Application Ref:	2025/0428			 <div>Ribble Valley Borough Council</div> <div>www.ribblevalley.gov.uk</div>
Date Inspected:	11/07/2025	Site Notice:	19/06/2025	
Officer:	EP			
DELEGATED ITEM FILE REPORT:				APPROVAL

Development Description:	Proposed first floor extension and rendering.
Site Address/Location:	Riverside Lodge Sawley Old Brow Sawley BB7 4LF

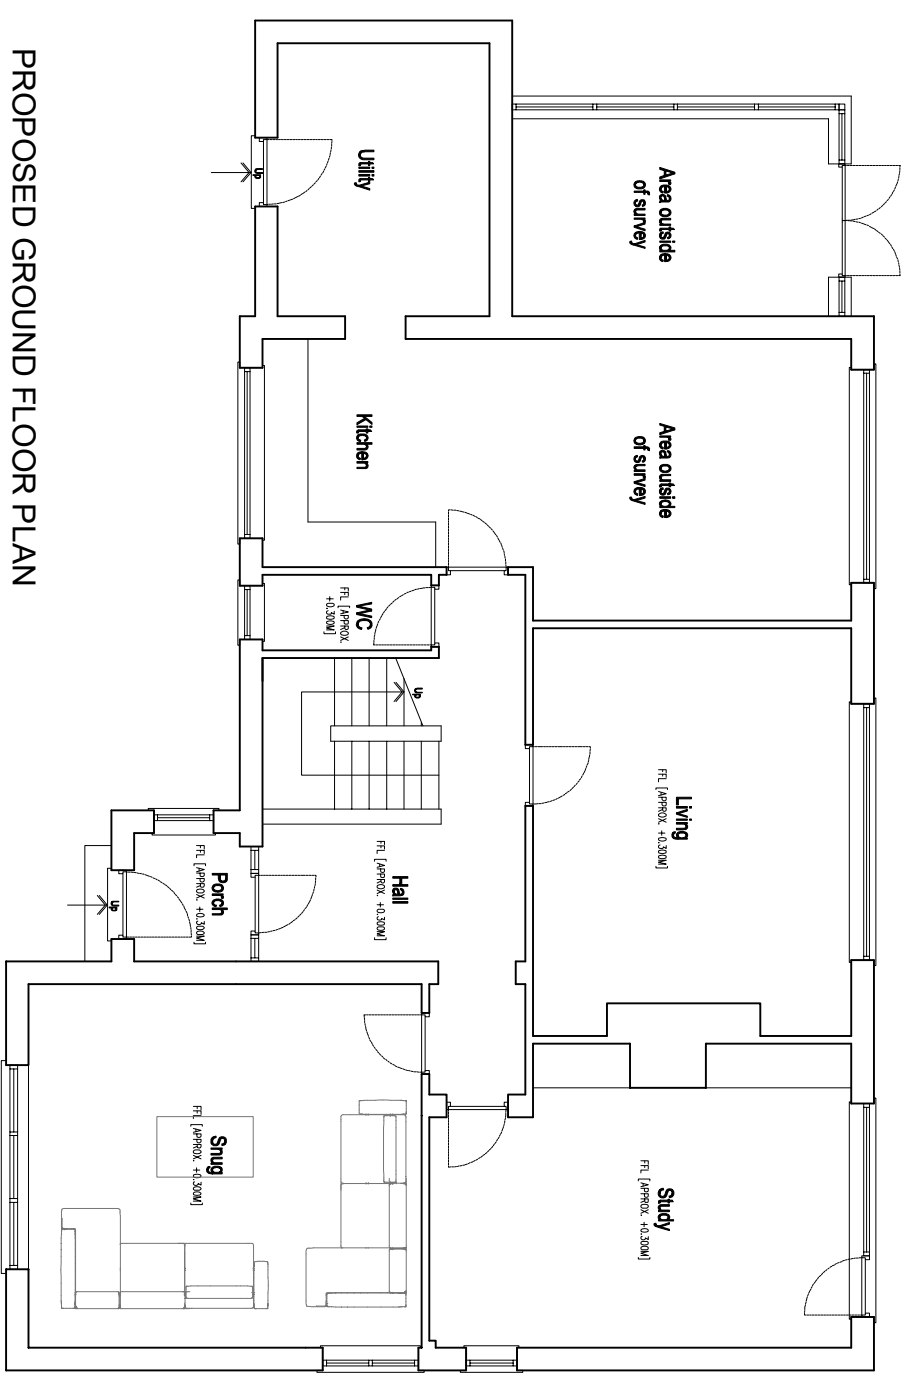
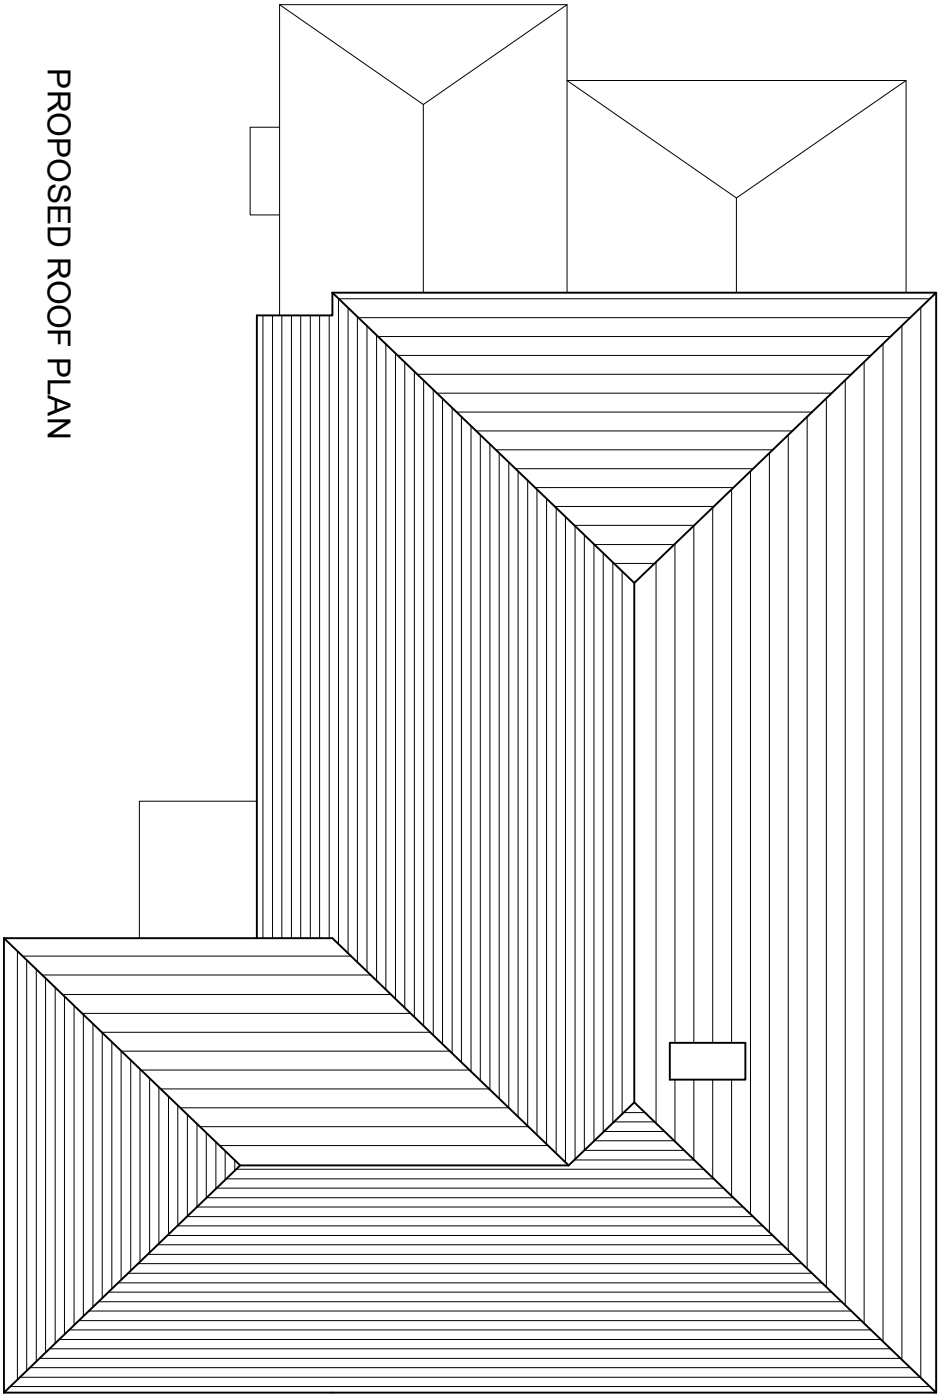
The proposed extension is located to the Northeastern elevation of the dwelling, where the neighbouring property, Park House, is located. The proposed first-floor extension is an infill extension and will sit on the same footprint as the existing dwelling. As such, there is only a small increase in built form proposed. In respect to impact on habitable windows, the neighbouring dwelling to the northeast is approximately 12m from the proposed development. This is a sufficient distance to mitigate any significant loss of light to said windows.

There is one new window opening proposed on the side elevation of the extension at first floor which faces the neighbouring property to the Northeast. This window will serve a bathroom and therefore it is expected that it would be fitted with obscure glazing. However, the plans do not stipulate this, so an appropriate condition will be placed on the decision notice to secure this, in the interest of mitigating any potential for overlooking.

Client MR & MRS FENN	Scale 1:100	Sheet Size A3	Job Number 25-022	Drawn By AW	Checked AW
Project RIVERSIDE LODGE SAWLEY	Drawing Title PROPOSED ELEVATIONS	Drawing Status PLANNING	Drawing Number PL07	Revision E	First Issue -

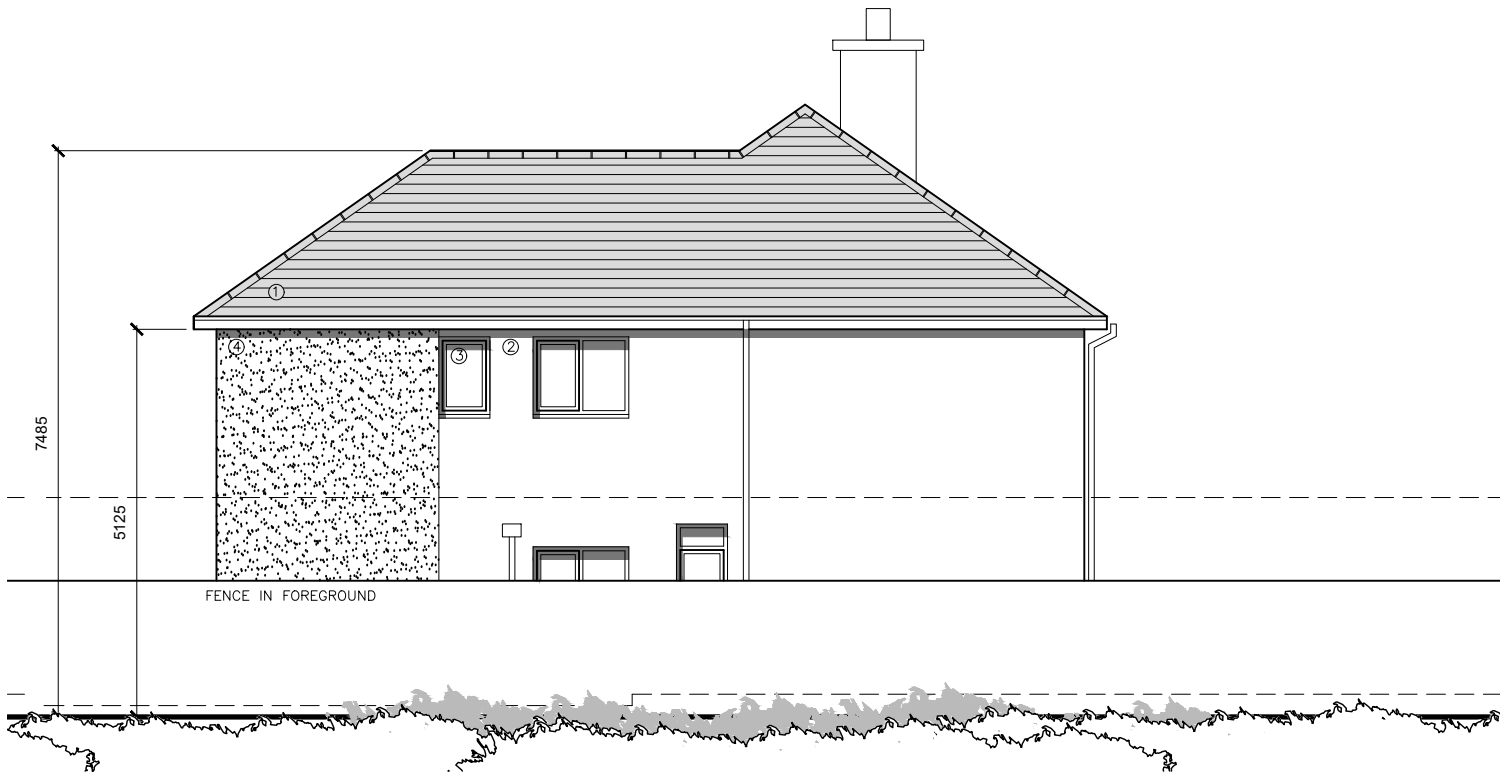
In respect to materials, the original scheme proposed the entire dwelling would be faced in render. Following discussion, the amount of render has been reduced to retain some of the original brickwork. As a result, the building will not appear overly contemporary within the conservation area. In addition, there are a number of properties within the vicinity of the dwelling that are faced in similar render. It's also important to recognise that the application dwelling is of more modern construction, and therefore the existing materials, namely uPVC windows and red facing brickwork, are more contemporary in nature. As such, it is not considered the development will be of harm to the visual amenities of the conservation area.

The proposed first floor extension will have an eaves and ridge height of 5.1m by 7.5m respectively falling below the height of the existing ridge. As a result, the extension will not be an overly dominant addition to the property and will remain somewhat subservient, despite its forward projection.

The existing outrigger is a converted garage in which the garage door opening has been replaced with patio doors. This does look somewhat anomalous on the principal elevation of the dwelling. The proposed scheme aims to remove the existing patio doors and replace them with a standard sized window opening. This will result in the fenestration reading as more cohesive and becoming consistent with a typical principal elevation.
